Appeal Decision

Appeal Ref: 6002684

15 Rusdene Road, Eastcote, Hillingdon HA5 1SW

- The appeal is made under section 78 of the Town and Country Planning Act 1990 (as amended) against a refusal to grant planning permission.
 - The appeal is made by Kamini Thayalanayagam against the decision of the Council of the London Borough of Hillingdon.
 - The application Ref is 63838/APP/2025/1660
 - The development proposed is described as the erection of rear canopy.
-

THE PROPOSED REPLACEMENT  
REAR CANOPY

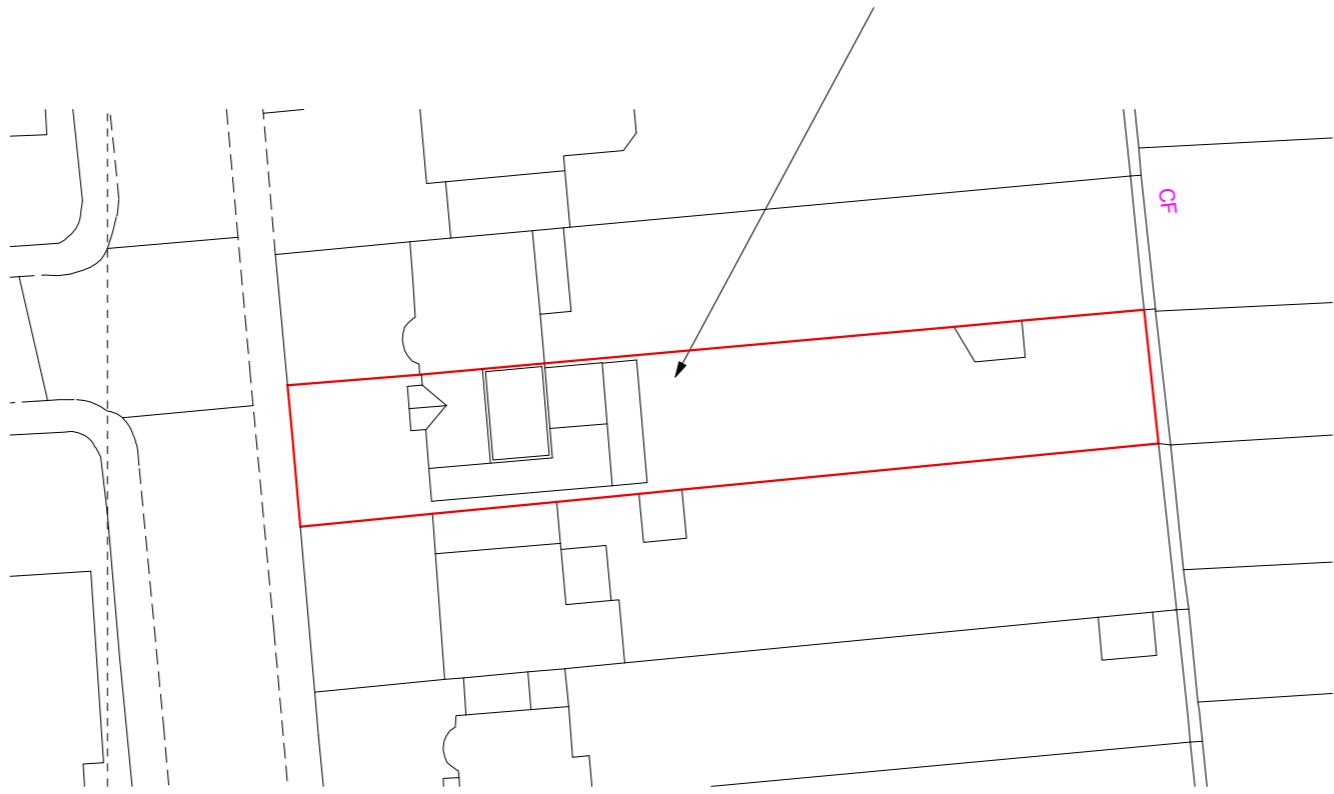
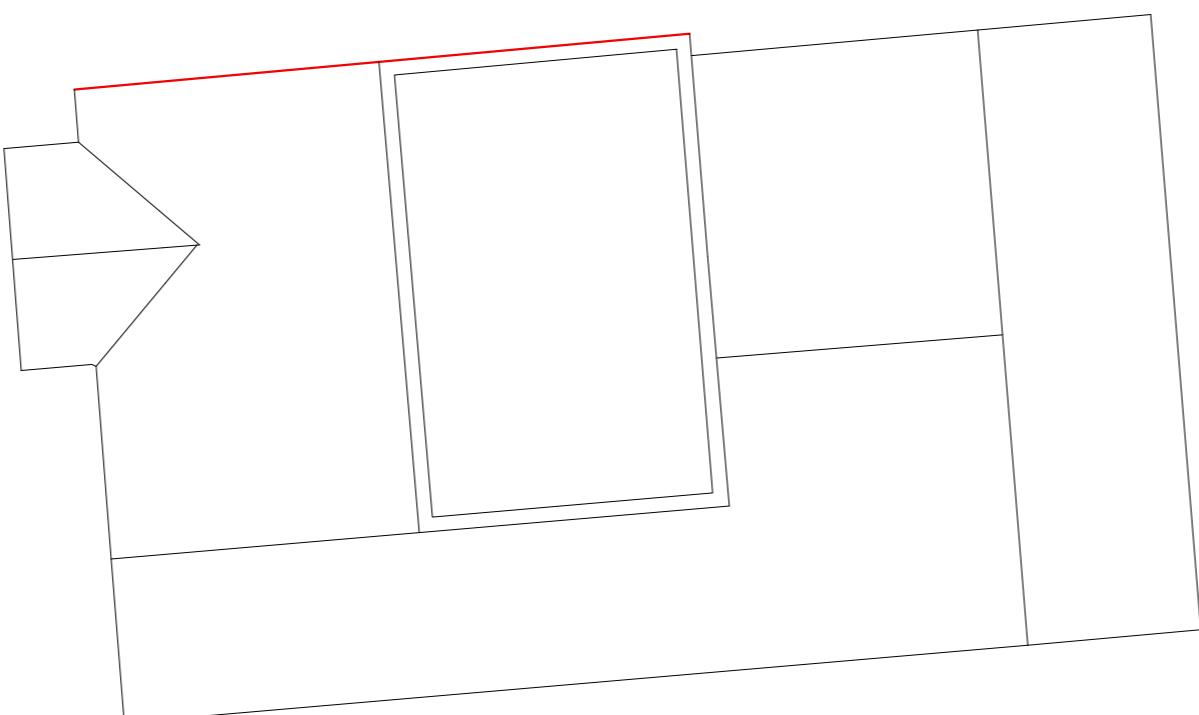
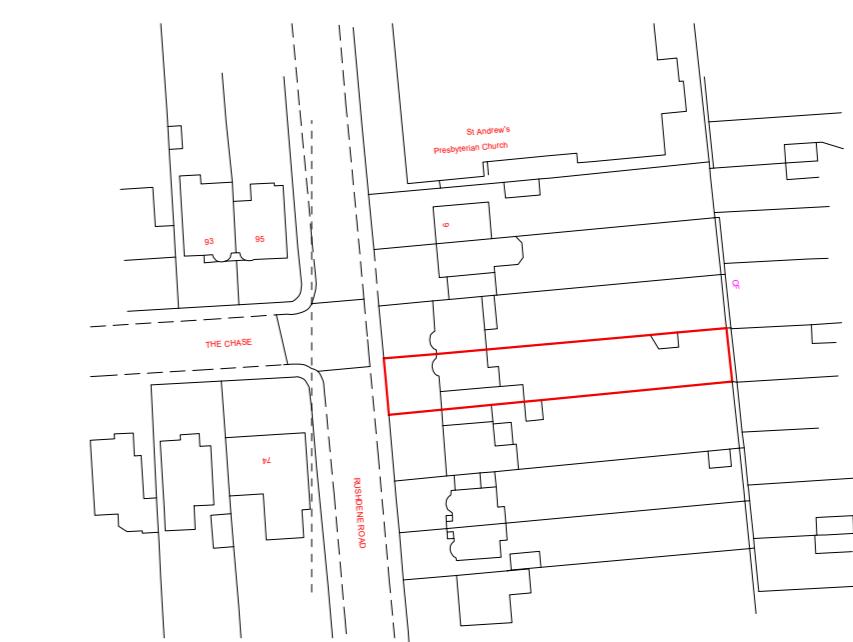
5. The proposed development is for the erection of a canopy attached to the existing single storey rear extension. I am aware that this proposal follows a previously refused scheme for a larger canopy. The canopy would sit below the eaves level of the existing extension and in line with the top of the rear door frame and would be constructed of timber posts and a translucent perspex style flat roof. The National Planning Policy Framework requires development to be well designed.

6. The canopy would extend further into the garden than other rear extensions in the locality and when combined with the existing extension would significantly exceed the suggested depth of 3.6 metres for rear extensions on wider plots set out in Policy DMHD 1 of the London Borough of Hillingdon Local Plan Part 2 Development Management Policies (January 2020) (LP).

7. The height, flat roof and openness on three sides would help to minimise the visual bulk of the structure. However, whilst no internal floor area would be added, the canopy would be a significant structure and the depth and width of the proposed addition would overly extend the rear of the property. The introduction of a flat roof structure adjoined to the existing pitched roof rear extension would be visually distinctive, but in an awkward way that would appear at odds with the established character of the dwellings in the surrounding area where extensions tend to have a simpler and coherent form. Although the proposal would be to the rear of the property and not visible in the public realm, it would be evident in private views from neighbouring rear gardens. In any event, development should respect its local context and character.

8. The materials have been chosen to be lightweight, providing weather protection whilst still allowing natural light onto the outdoor patio. However, the existing building features tile hanging, cream painted render and an existing extension in red brick. The proposed materials would not match the existing dwelling style and the use of perspex would be at odds with the high quality materials used in the dwelling and the rear extension. The proposed canopy would detract from the appearance of the rear of the dwelling and appear discordant.
